## **Boston Alternative Energy Facility**

### Third Report on Outstanding Submissions

Planning Inspectorate  
Reference: EN010095

Document Reference: 9.78

BOSTON ALTERNATIVE ENERGY FACILITY DEVELOPMENT CONSENT ORDER
Regulation 5(2)(o) - Bat Survey Transects
BOSTON BOROUGH COUNCIL
Sheet 1 of 1

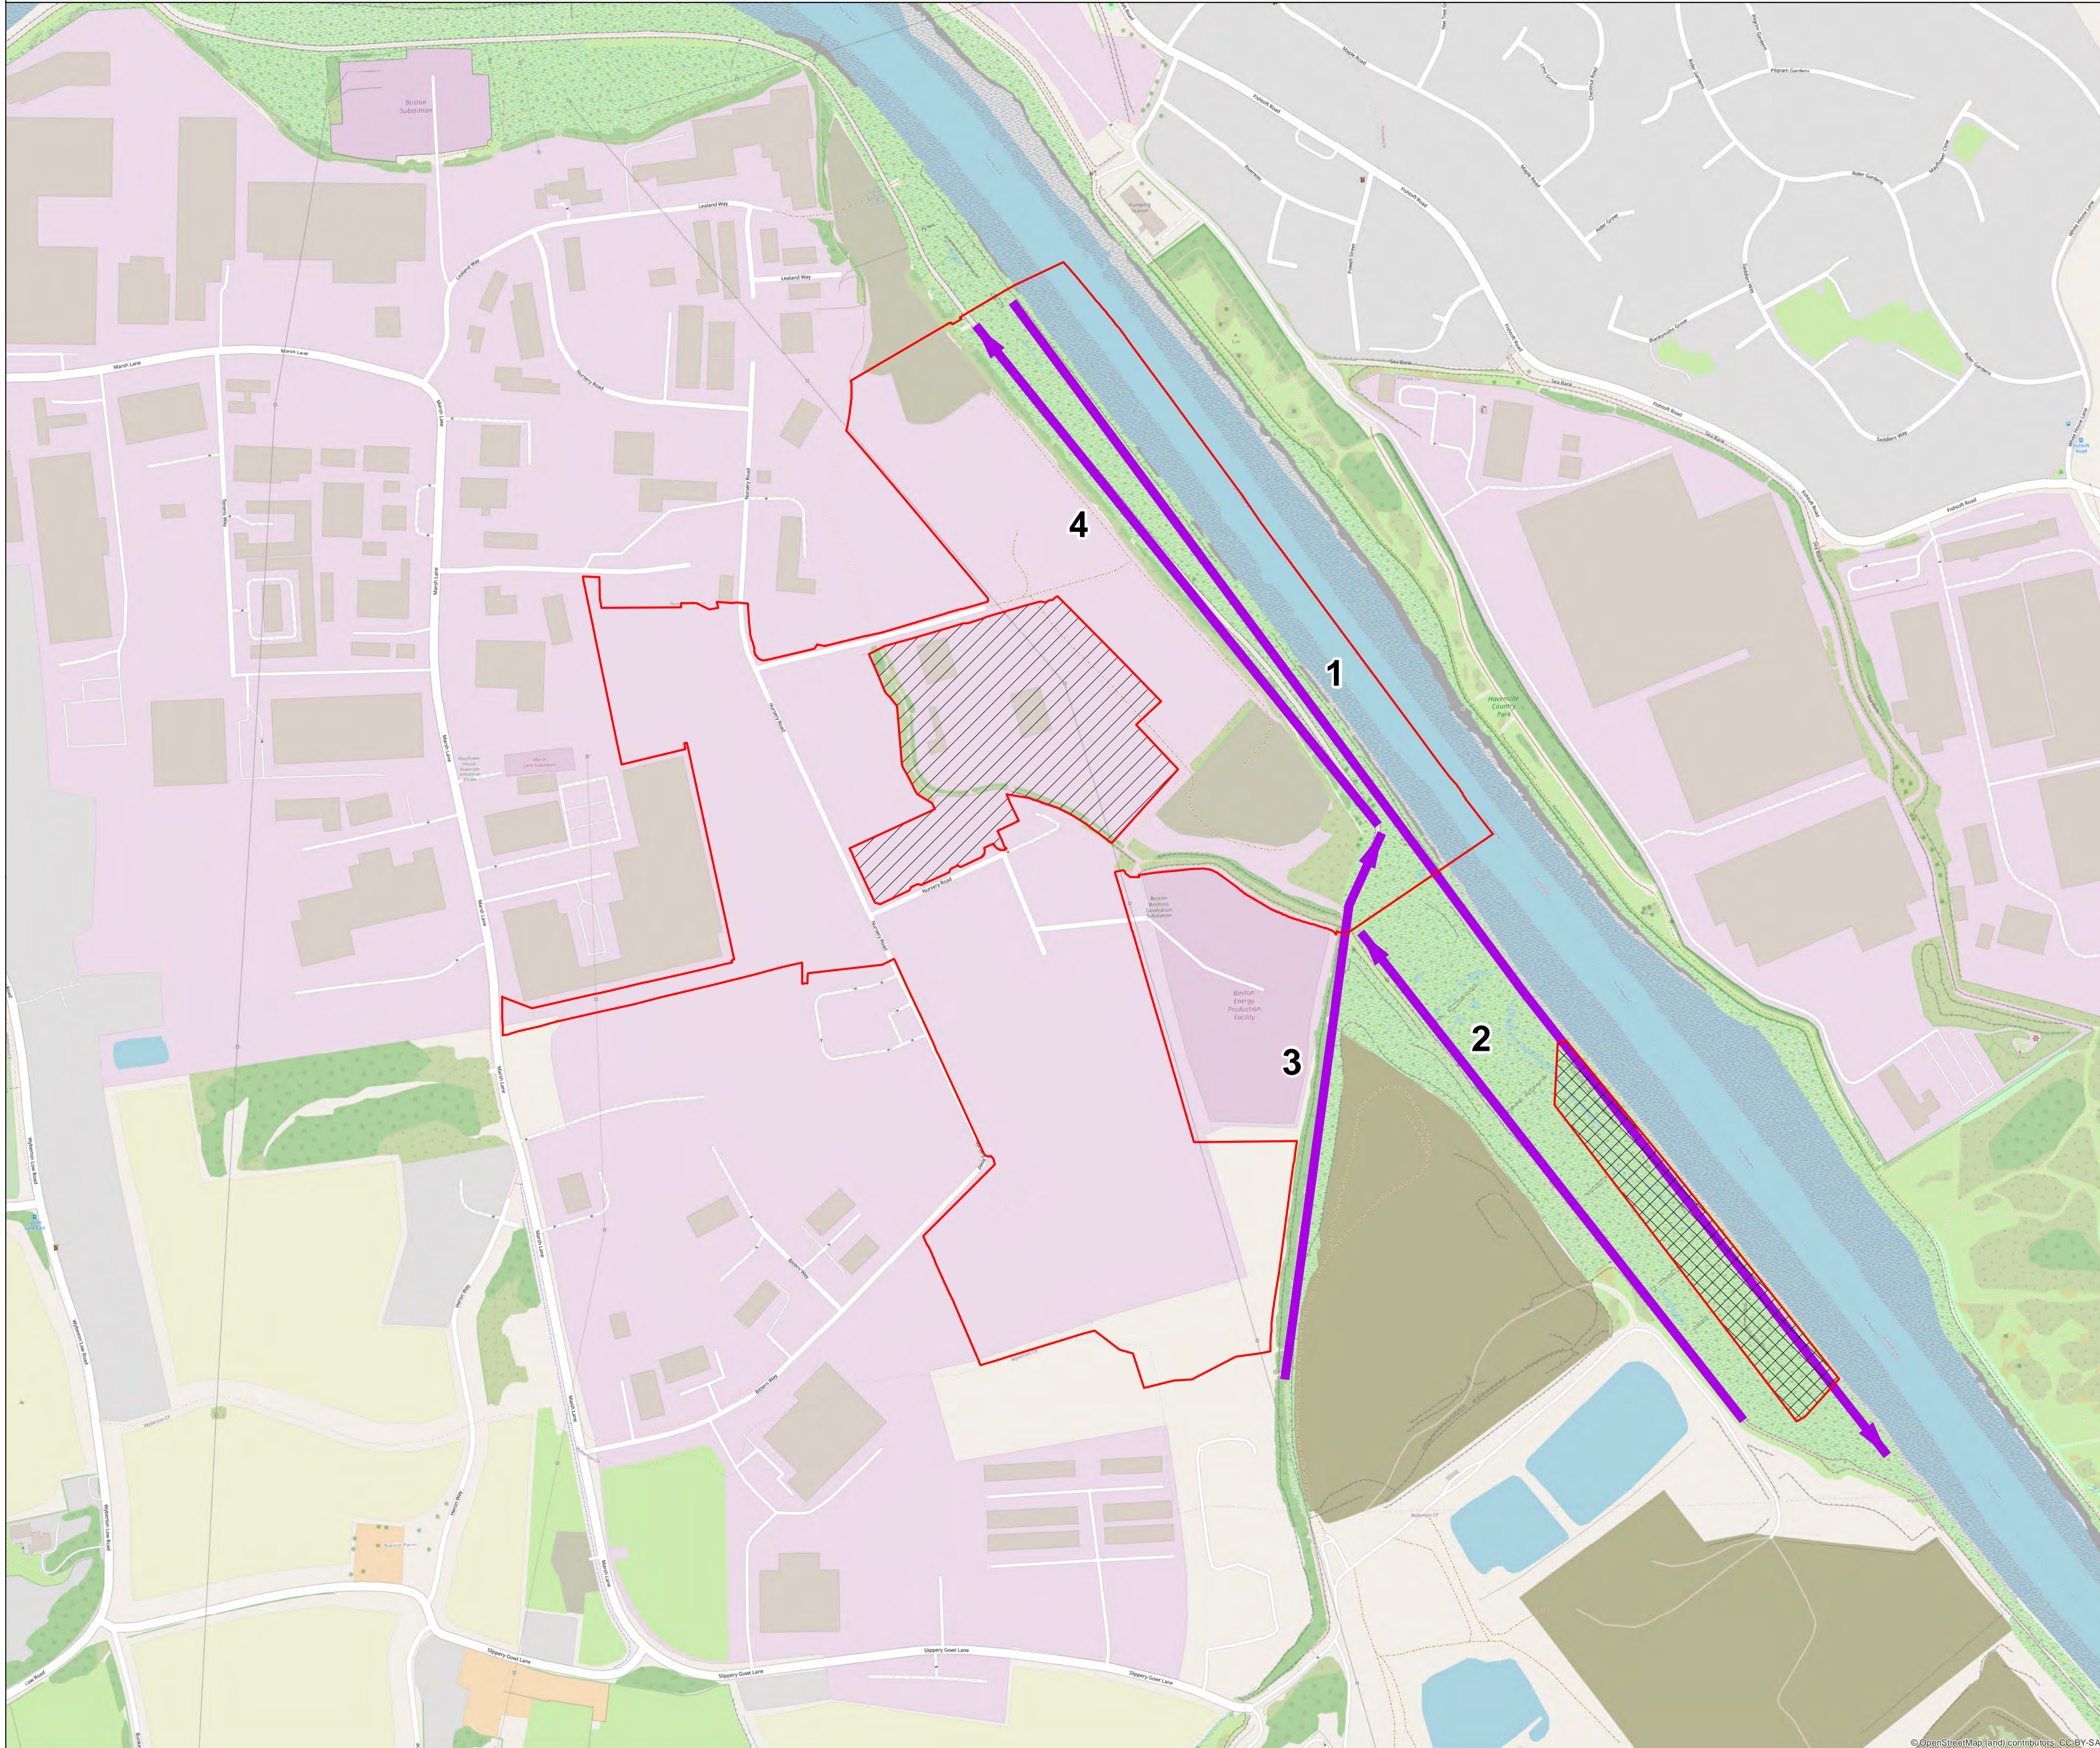
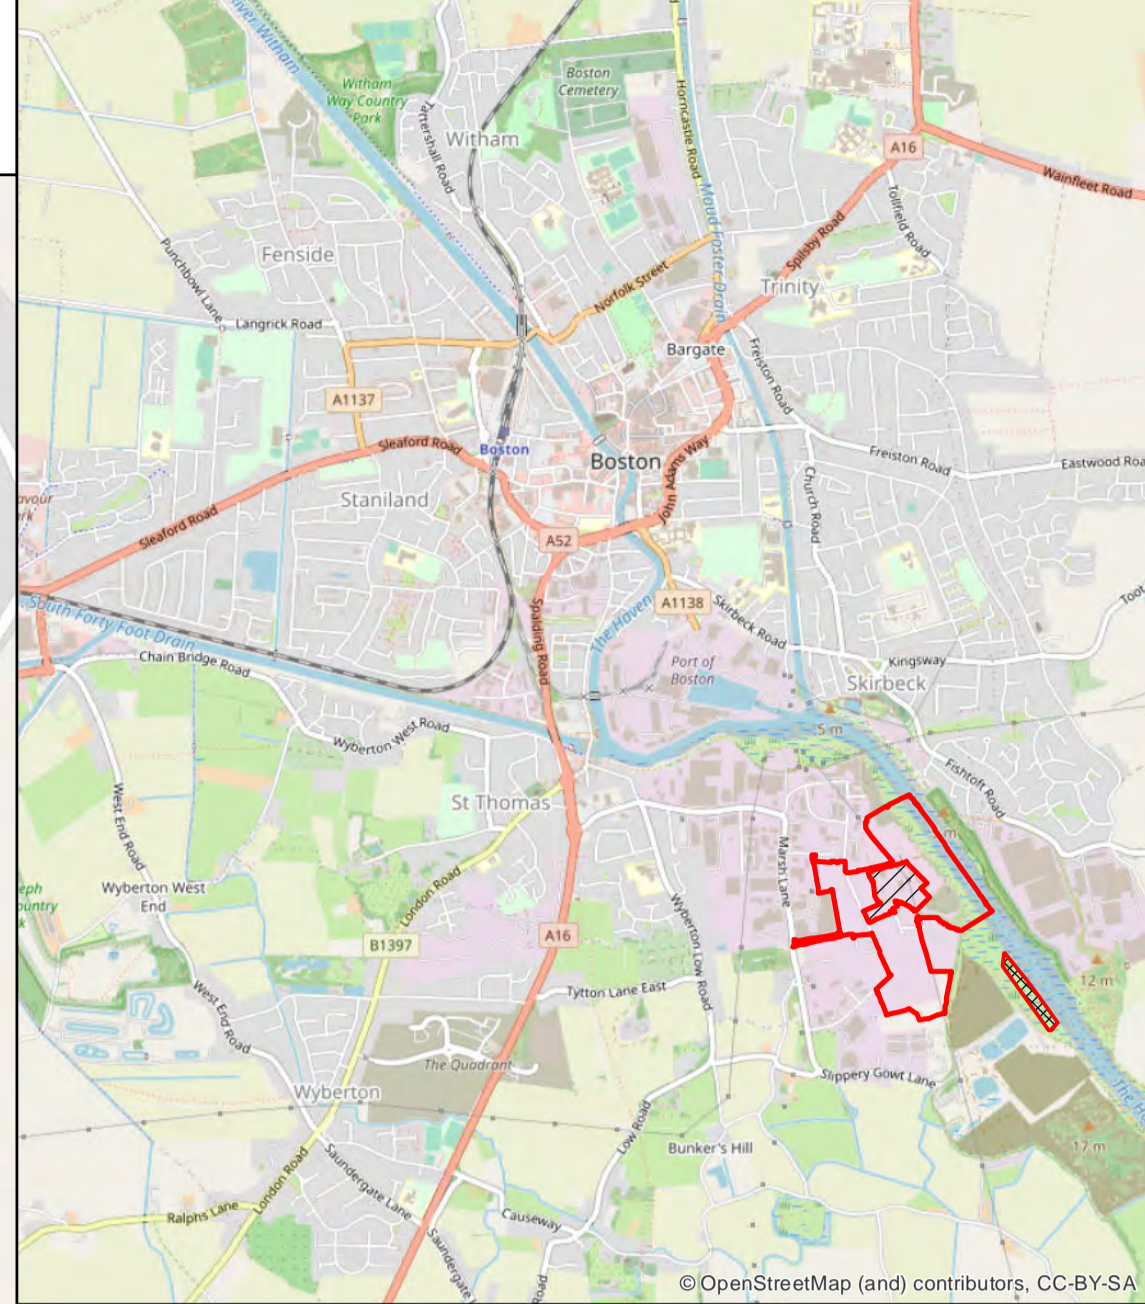
| No. | Comment  | The Applicant's Response  |
|-----|--|---|
| 3   | <p>Information regarding the route of 4 transects has been included at paragraph 5.1.3. of the updated OLEMS [REP3-008] and illustrated at Appendix 2 (drawing PB6934-RHD-01-ZZ-DR-4023). However, there are no details of any right bank transects. Is the Applicant intending to carry out this additional suggested transect? We note at 1.7 that the specific location and type of bird and/or bat box will be determined by a suitably qualified ecologist prior to the implementation of the final landscape mitigation planting scheme.</p> <p>Natural England have since noted in an email to the Applicant "The transect survey locations are acceptable, given these are focused on the most suitable areas for bats and further transect surveys are not considered necessary.</p> <p>It would be advisable to re-assess the suitability of the trees closer to the impacts to ensure their suitability has not change since the 2019 surveys (i.e. pre-commencement surveys)."</p> | <p>The right (eastern) bank of the River Haven was not included in the bat survey effort undertaken by the Applicant. This section of bank is not within the Application Site. Furthermore, and in combination with The Haven providing a buffer, no indirect or direct impacts were predicted to foraging/commuting bats (if present) along the right bank. Through the implementation of the appropriate mitigation measures for foraging/commuting bats and the proposed lighting requirements being designed in accordance with the BCT guidance, any potential indirect or direct impacts that may be experienced by foraging/commuting bats (if present) would be considered sufficiently mitigated and managed.</p> <p>As presented in the Outline Landscape and Ecological Mitigation Strategy (OLEMS) (document reference 7.4(1), REP3-007), the Applicant has committed to undertaking pre-construction surveys. This effort will include the checking on all previously recorded site conditions (including trees for their suitability to support roosting bats) to confirm that there have been no changes in site conditions since the previous surveys. The findings of the pre-construction survey effort will be presented in the final LEMS that will be submitted to discharge Requirement 6. Should there be any significant changes to baseline conditions observed during the pre-construction surveys, these will be communicated to</p> |
